Plymouth Engineering, Inc.

August 29, 2016

Project No. 16055

Response to Comments – 7-Unit Building, 30 Merrill Street, Portland, Maine

TYPICAL TRENCH SECTION
NOT TO SCALE

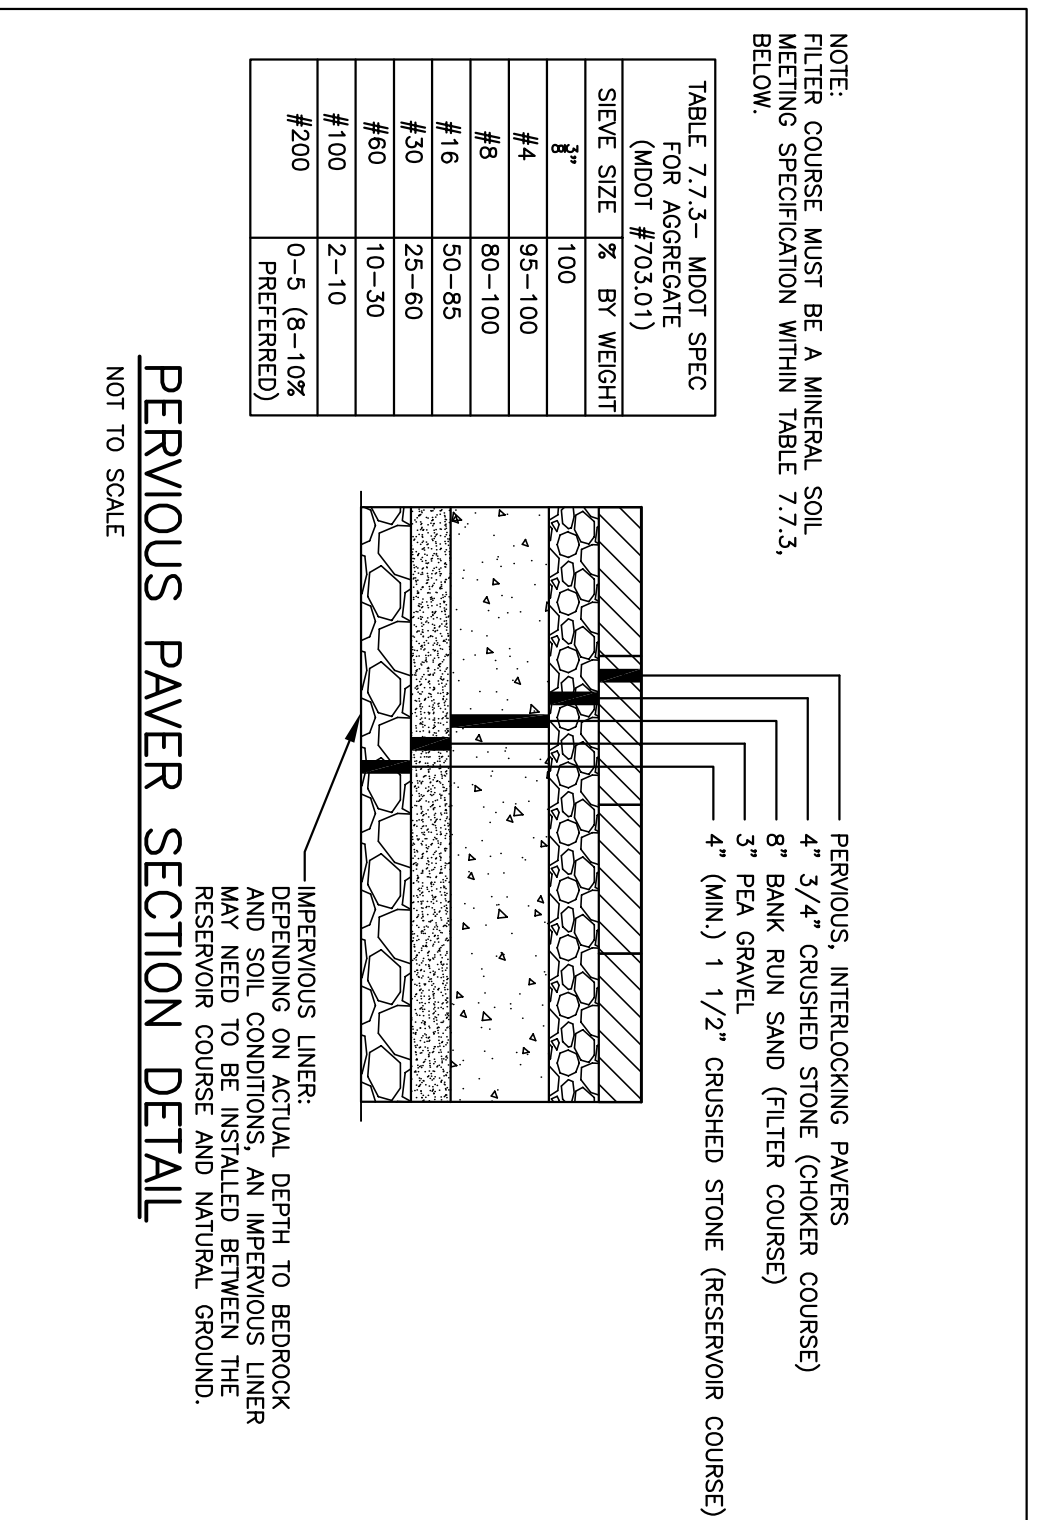
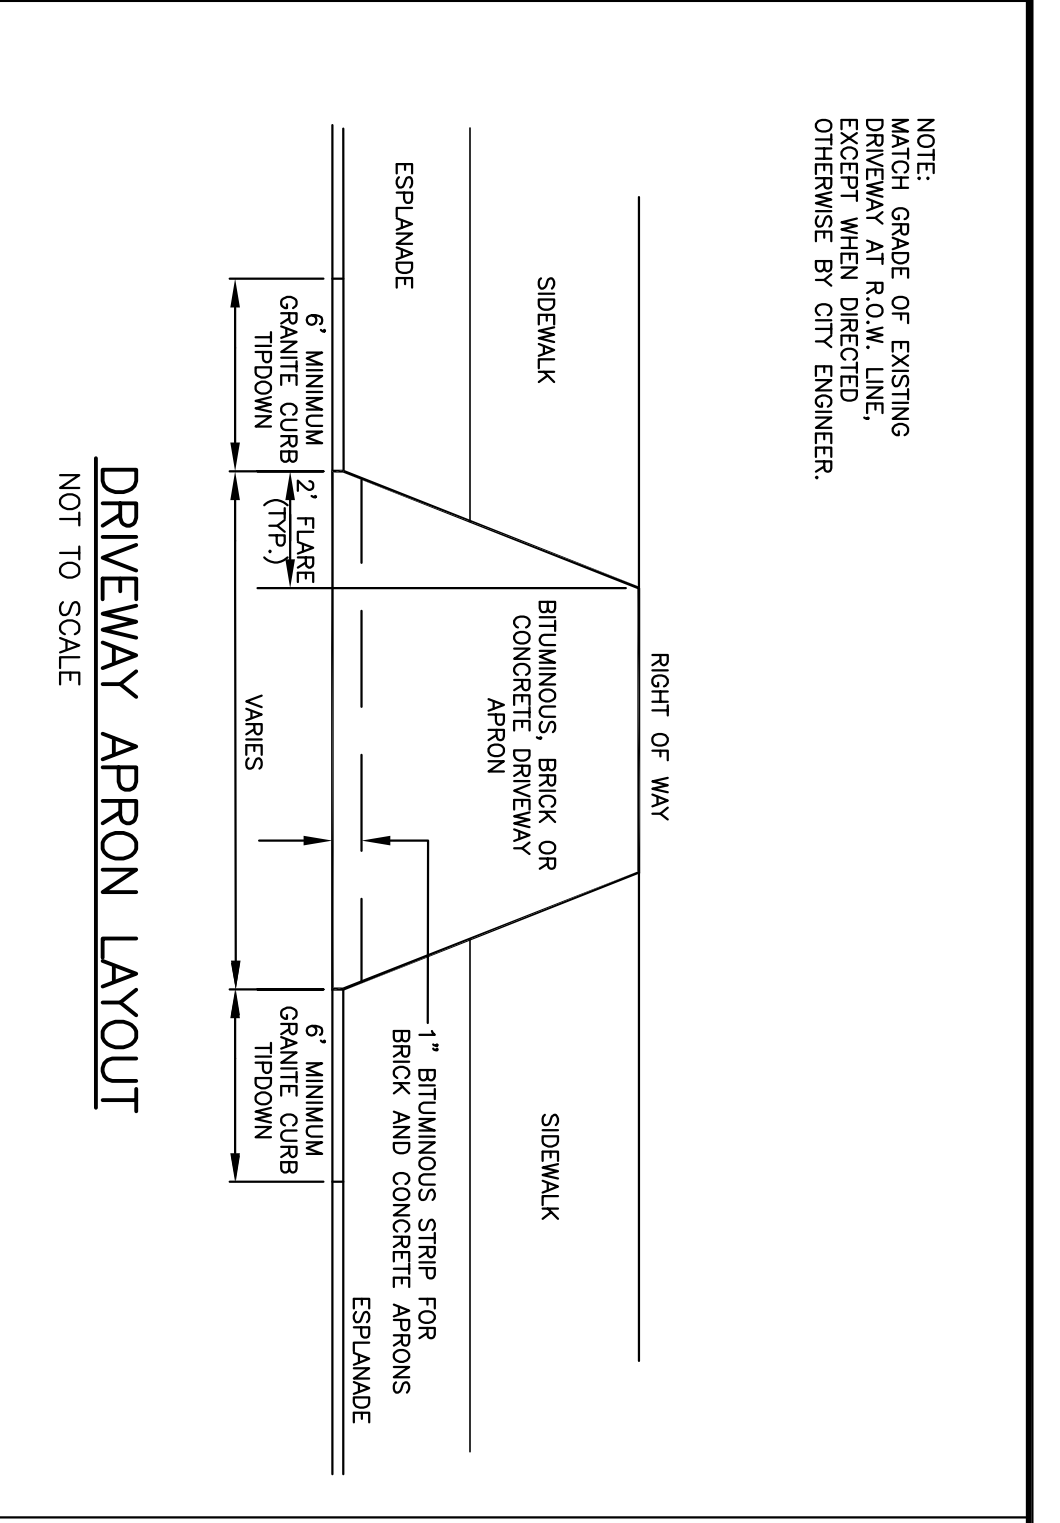
3) *The Applicant should provide a detail for pipe trenches, brick sidewalk repair, and pavement repair within the City of Portland Right-Of-Way per the City of Portland Technical Manual.*

We have added these details to the plans.

PERVIOUS PAVEMENT SECTION DETAIL
NOT TO SCALE

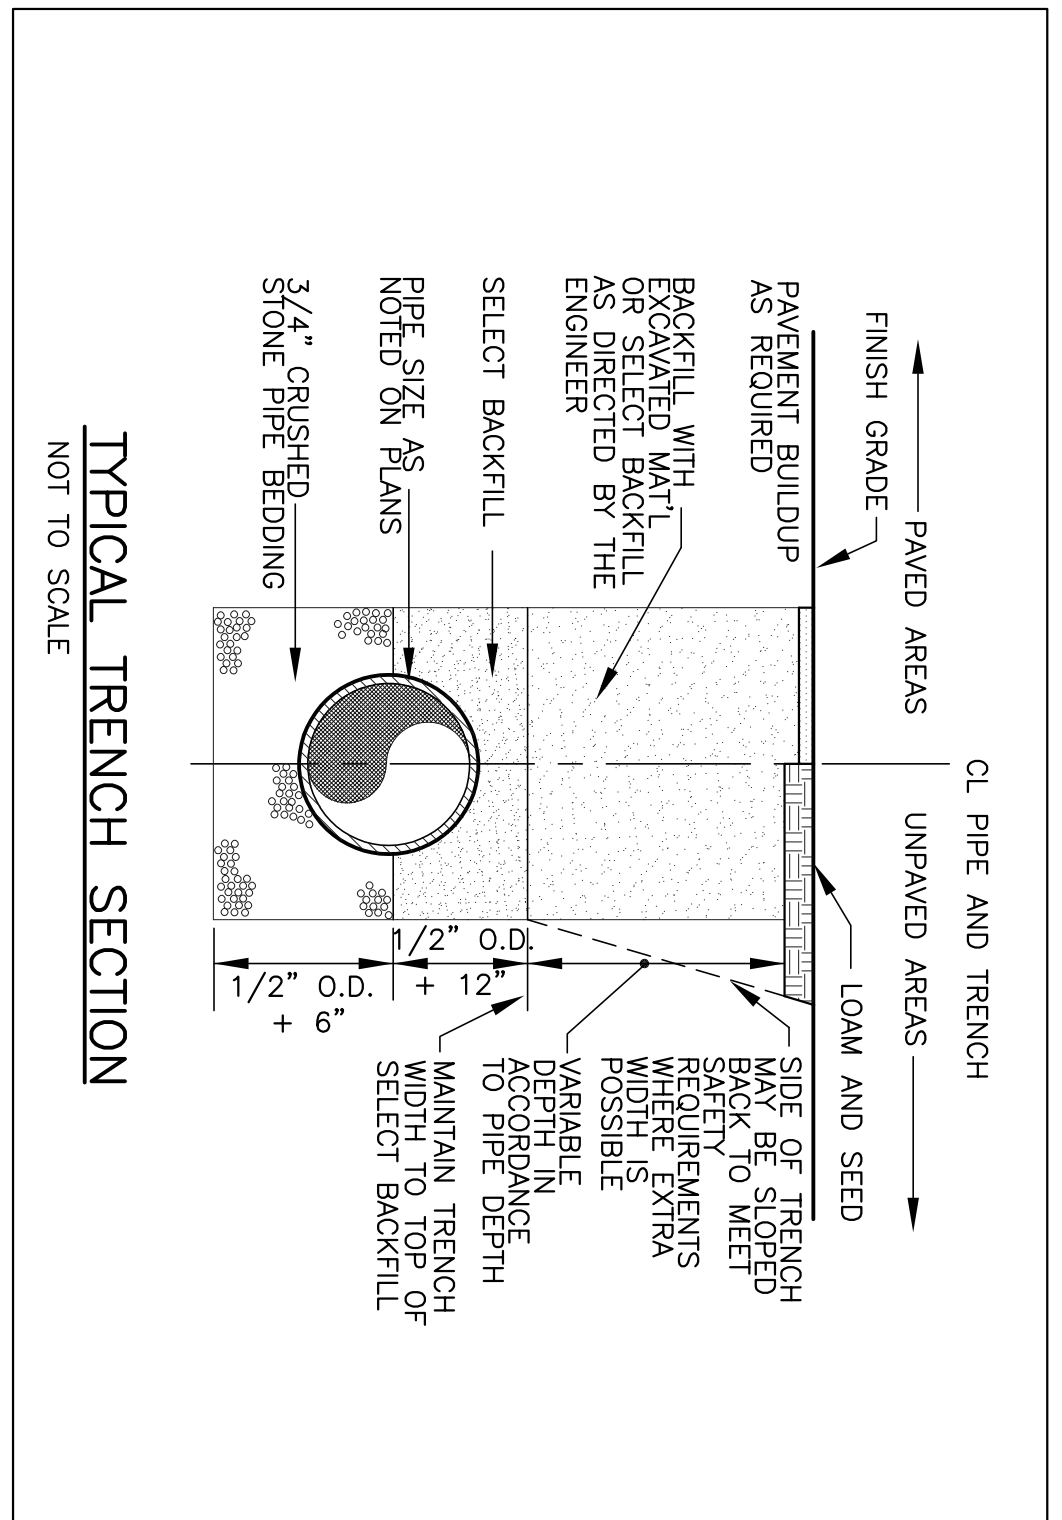
- The Pervious Paver Section Detail provided on Sheet C2 includes a Filter Layer; however, the Site Plan and stormwater management plan indicate that the limit of the proposed filter bed does not extend over the full area of proposed pervious pavers. A detail should be provided for paver installation in areas outside of the filter bed, to confirm that the entire paver area may be considered pervious. If the additional pavers are not installed in such a way that they are pervious, the impervious surface calculations should be updated, and the filter area should be designed per the Maine DEP Stormwater BMP manual's guidance for "Run-On Modular Pervious Pavement."*

- The Pervious Paver Section Detail should include specifications for the filter layer per Chapter 7.7 of Volume III of the MaineDEP Stormwater BMP Manual.*

The plans and calculations have been updated to show that the entire parking area and driveway are to be consistently constructed as pervious pavers.

We have added this information to the detail.

BICYCLE RACK SPECIFICATION - BIKE HITCH

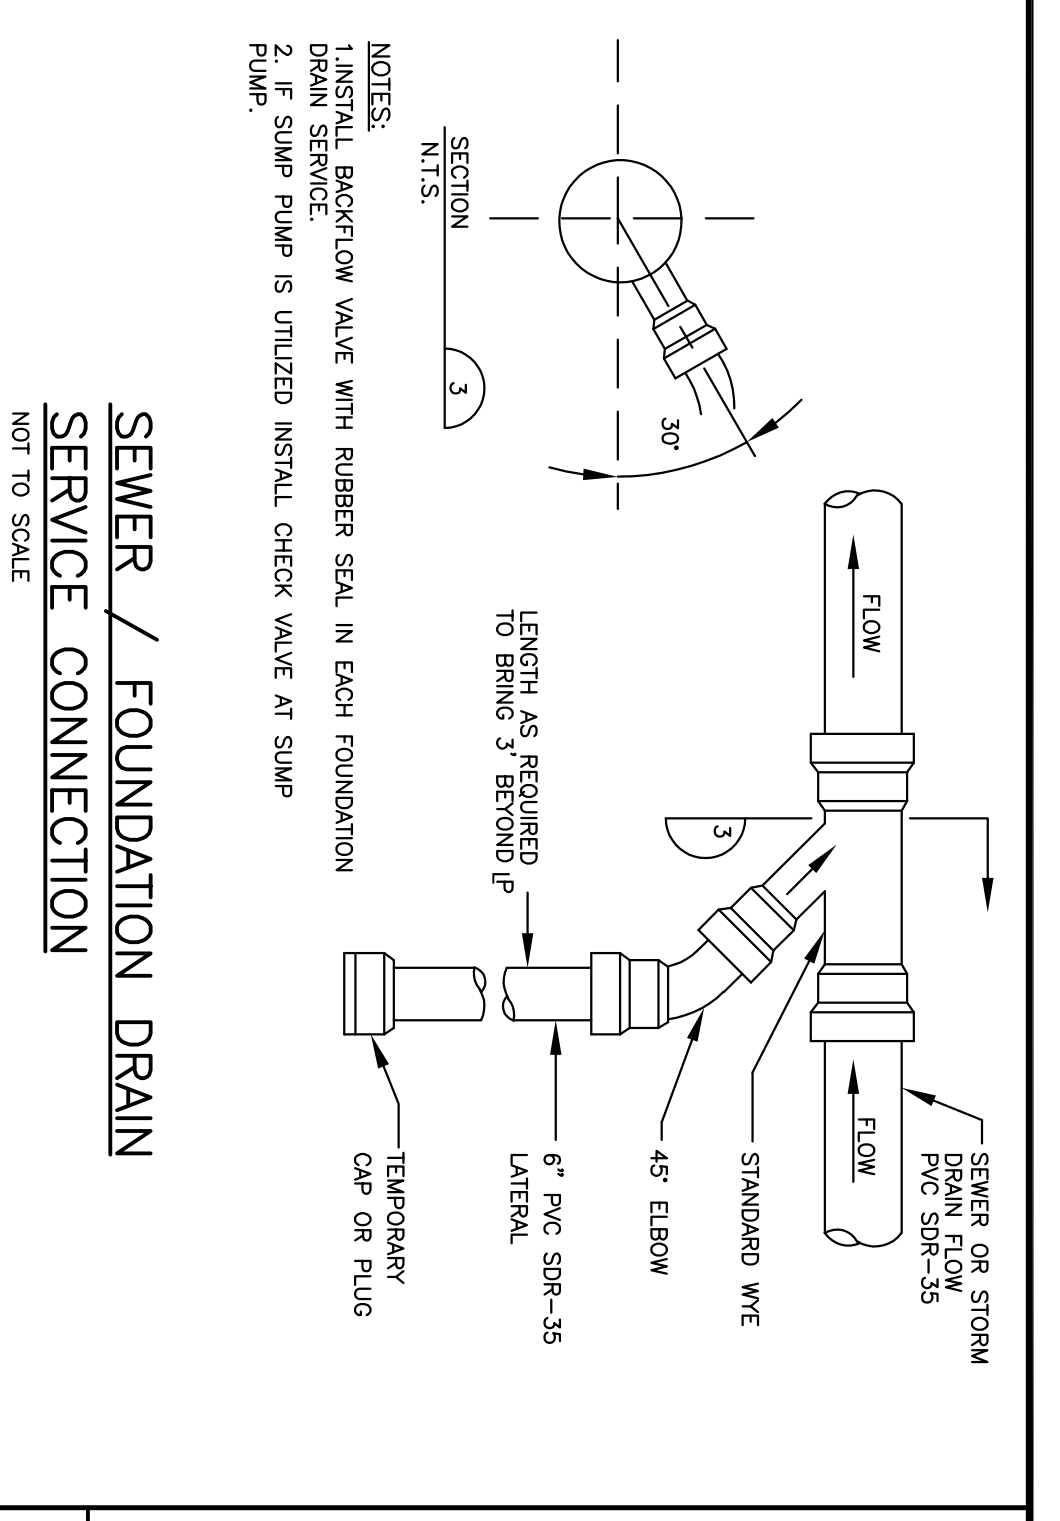
- *Bike Parking.*

To add to your response on this issue, we have added the location of the bike rack on the front sidewalk. We have provided an excerpt from the Technical Design Manual as well. This is located on the last detail sheet, Sheet C5.
